Martin Nugent
01254 828060
D3/12/0654

Drafted 11 September 2012

Planning Applications, Ribble Valley District
3/12/0654 17 George Lane, Read

Client	Mr and Mrs Elliott
Job Title	Proposed Alterations
	Pendle House
	George Lane
	Read
Drawing Title	Proposed
	Plans and Elevations
Scale	1:100
Date	JULY 2012
Drawn	DL

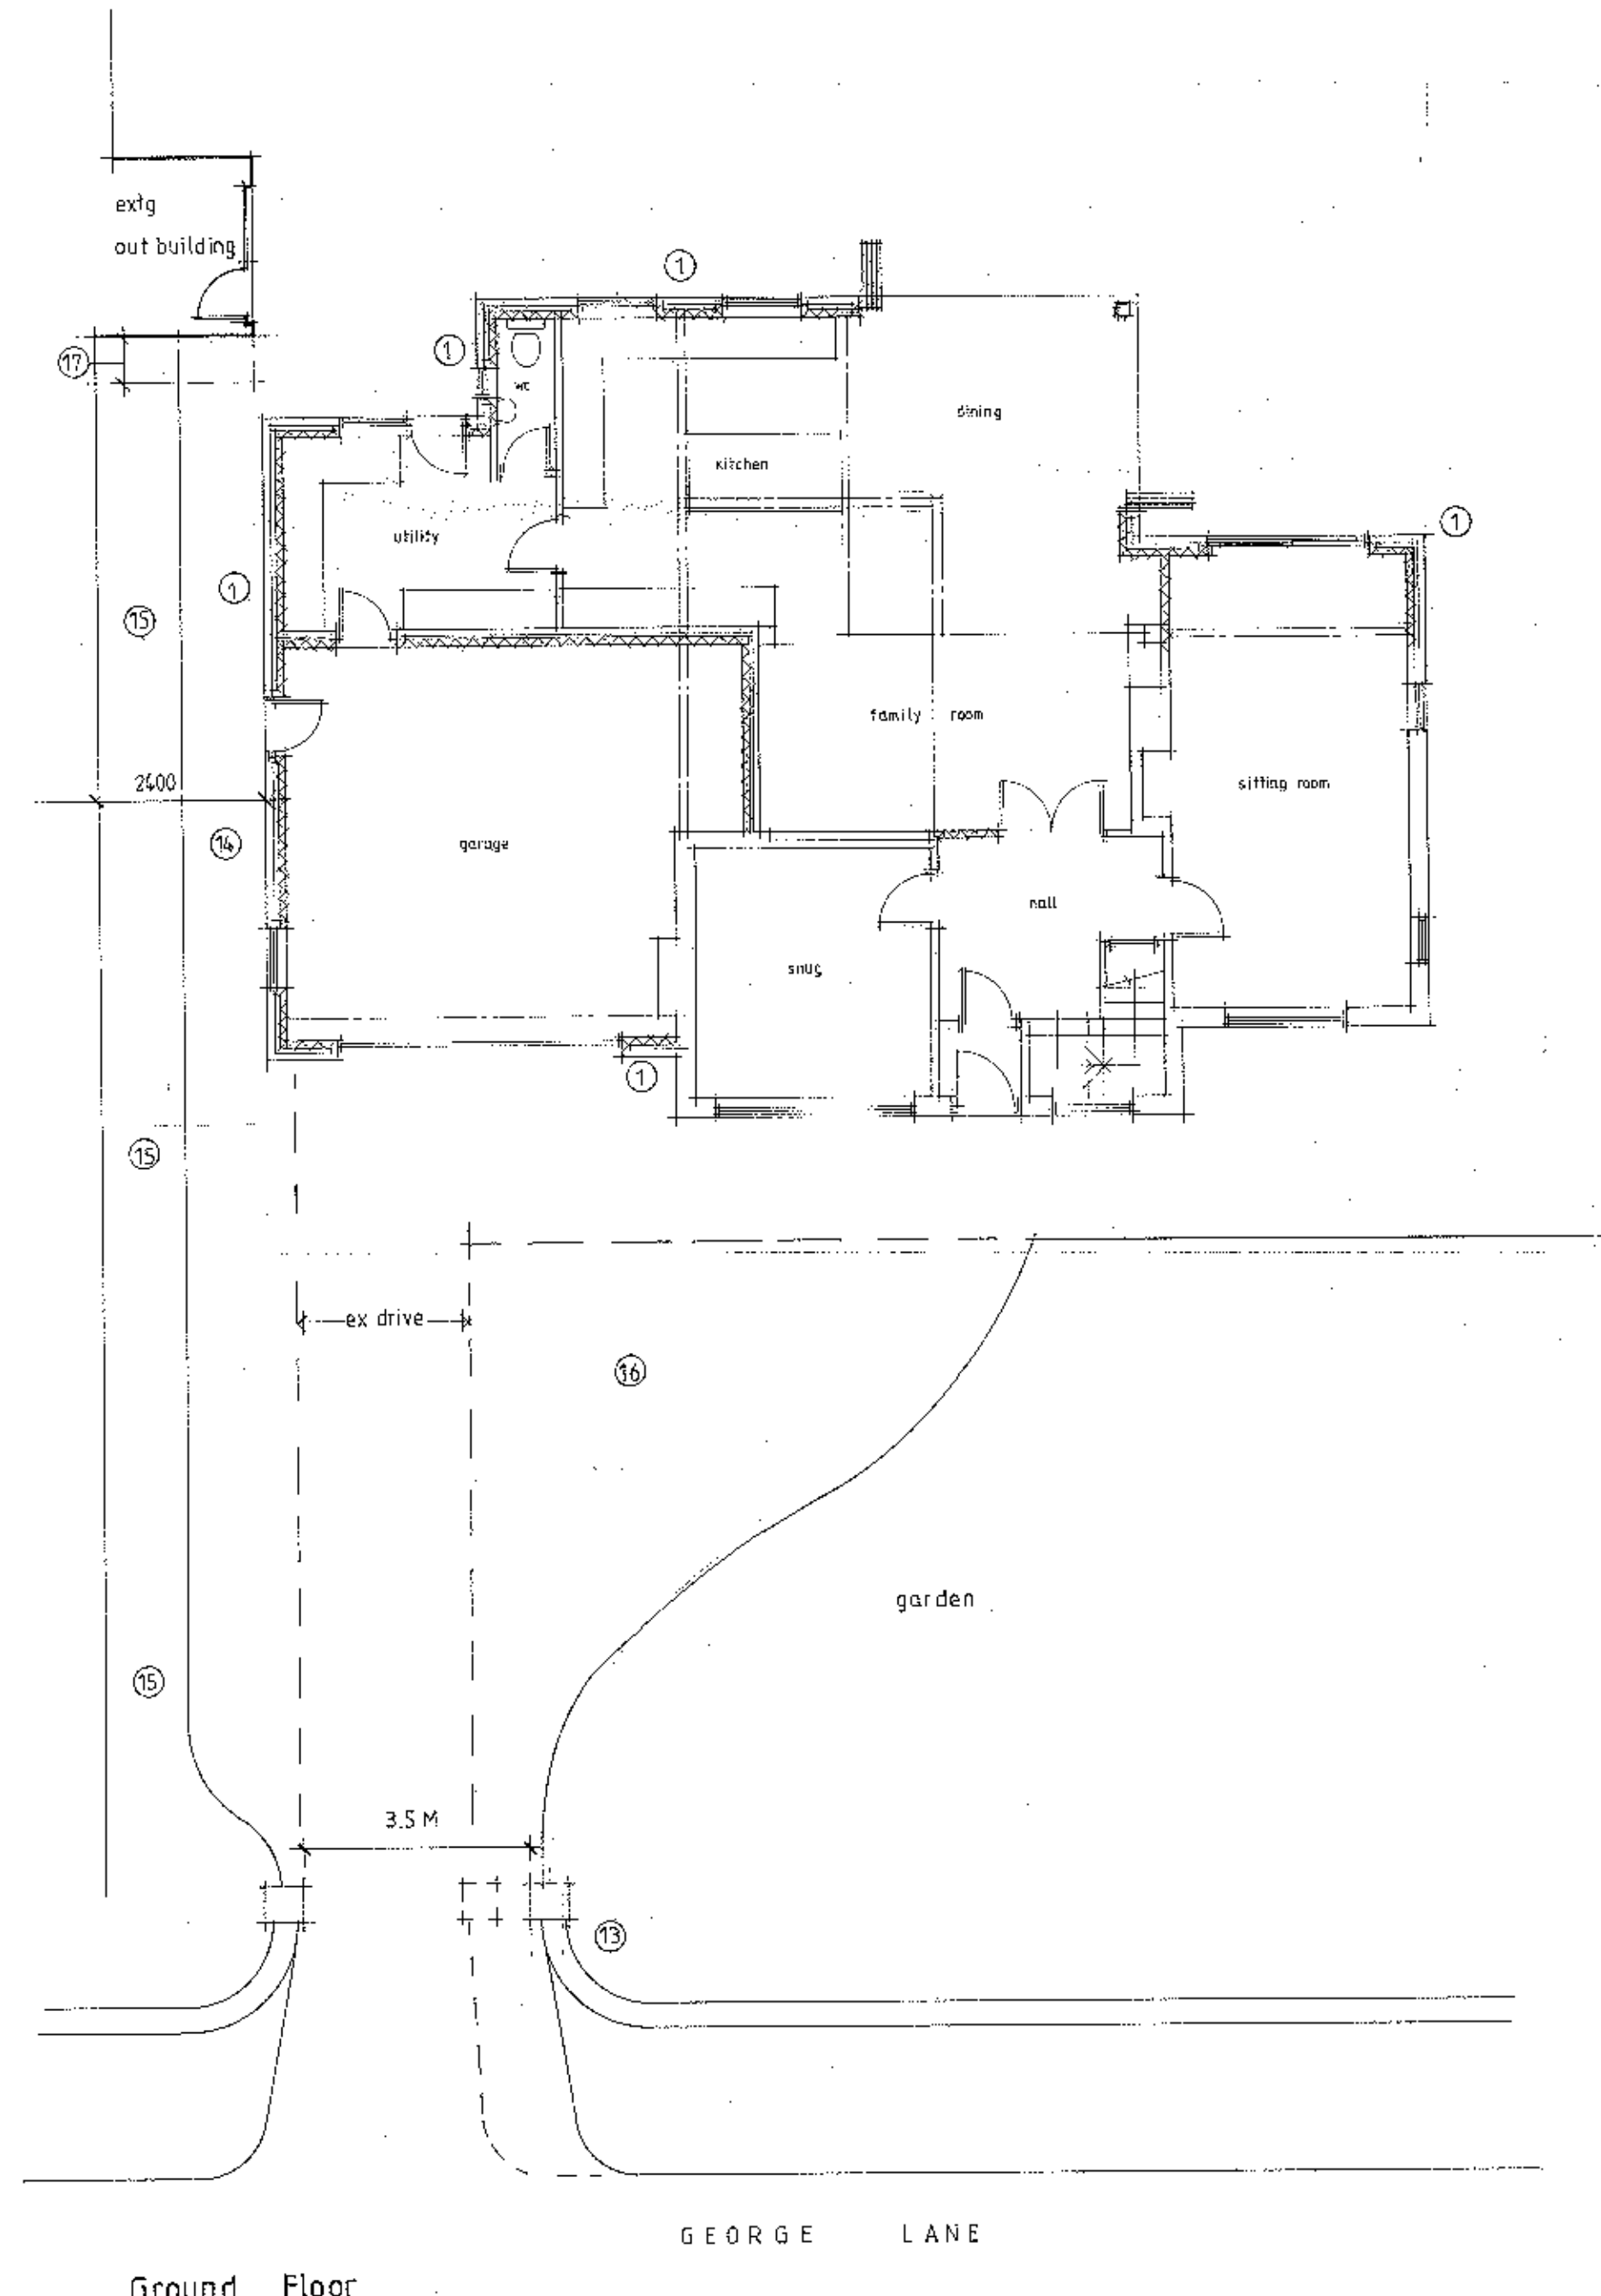
I have no objection in principle to this application on highway safety grounds. The widening of the driveway will benefit access for residents and improve conspicuity.

While the impact of the large mature tree to the north of the access remains significant, the proposed development does provide marginal highway safety benefits.

A. The kerbing at the vehicular crossing shall be reinstated in accordance with the Lancashire County Council Specification for Construction of Estate Roads, concurrent with the formation of the improved access. This is to provide the necessary access and to maintain the proper construction of the highway.
